**WEST SUSSEX COUNTY COUNCIL
INFRASTRUCTURE CONSULTATION**

SUBJECT: BE/49/10-COU of existing premises from B8 (storage) to B2 (General Industry) and MOT testing.

Clock Park, Unit 5A, Shripney Road, Bersted, Bognor Regis, West Sussex, PO22 9NH

Existing Floor Plan

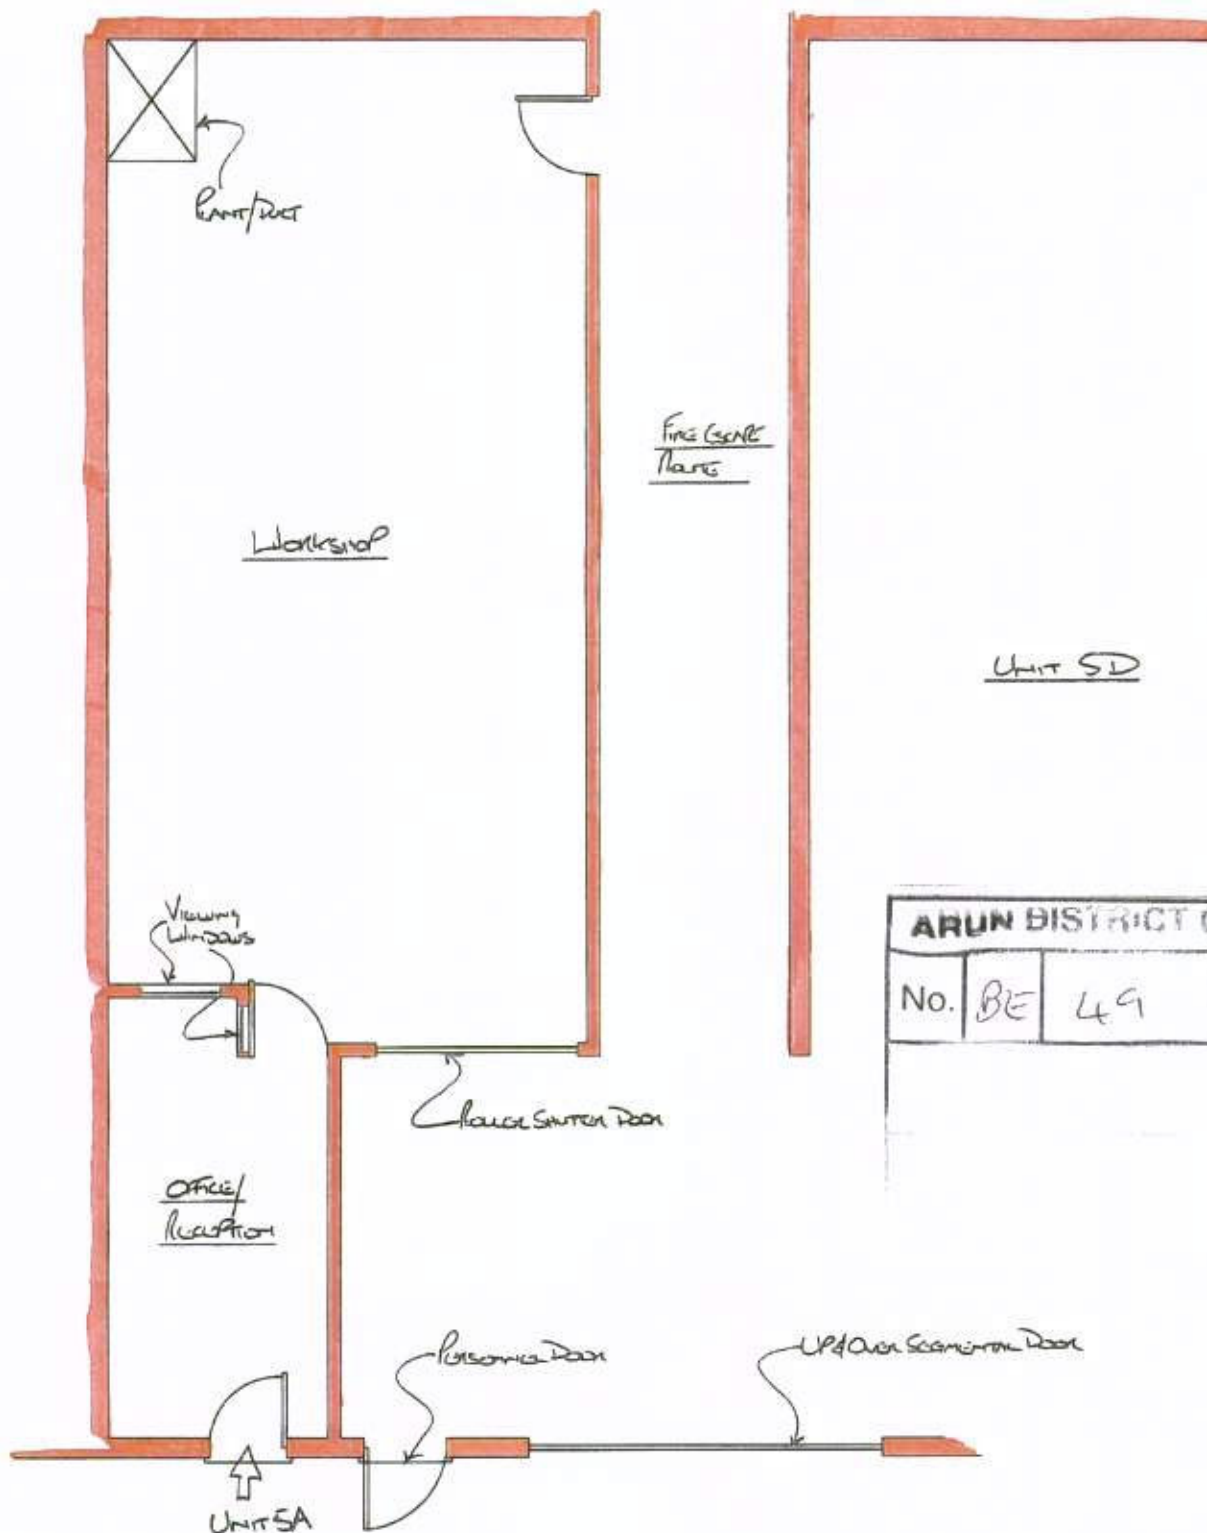
Having assessed the latest plan it is apparent to the south of the site there are three large spaces shown on the plan. From our previous knowledge of the site this area was used for the storage of old tyres. We would request the applicant to confirm whether this land is under their control and if yes could the area be used to house some extra parking?
